# BARBARICK RECYCLING AND REFUSE TRANSFER STATION

SITE DEVELOPMENT PLAN  
DECEMBER 2023

BARBARICK WASTE TRANSFER STATION  
EL PASO COUNTY, COLORADO  
SITE DEVELOPMENT PLAN  
COVER SHEET

BARBARICK WASTE TRANSFER STATION
 EL PASO COUNTY, COLORADO
 CONSTRUCTION DOCUMENTS
 OVERALL SITE PLAN

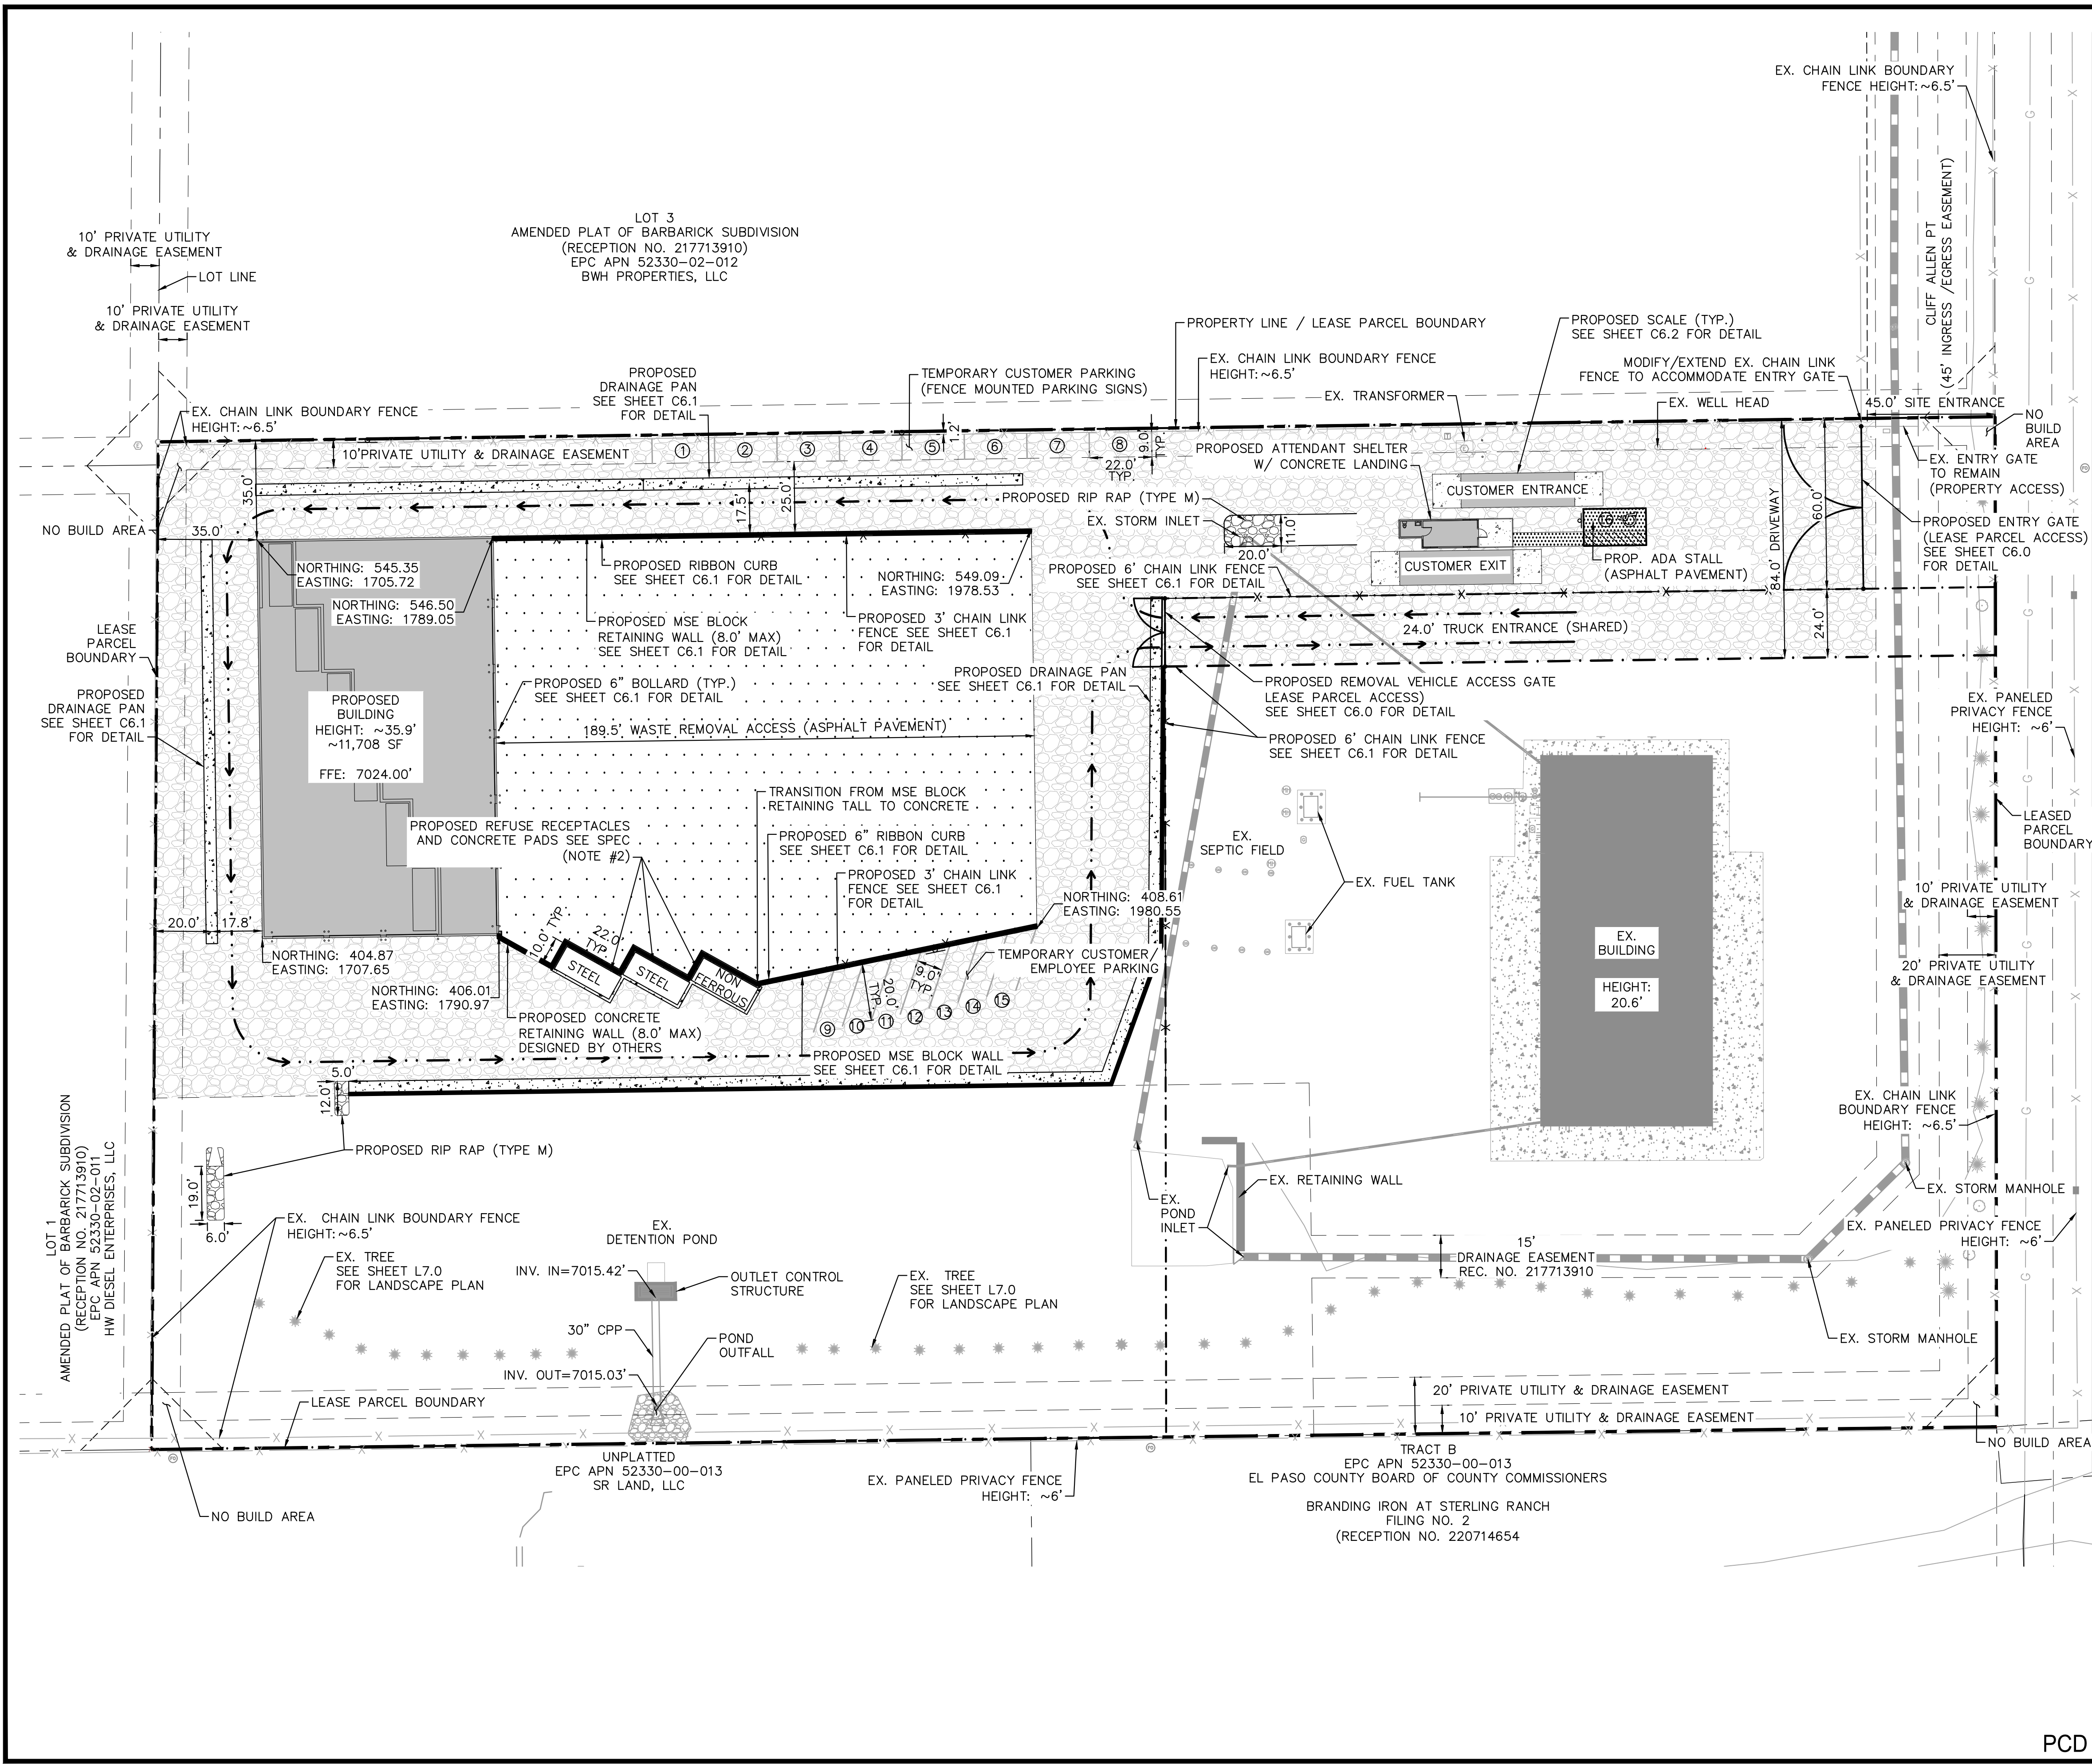
Please include:  
-dimensions of property lines  
-ADA parking spot

Please include:  
-building dimensions  
-setback distances from property lines

Please depict setback distance

Please label proposed storm sewer pipe.
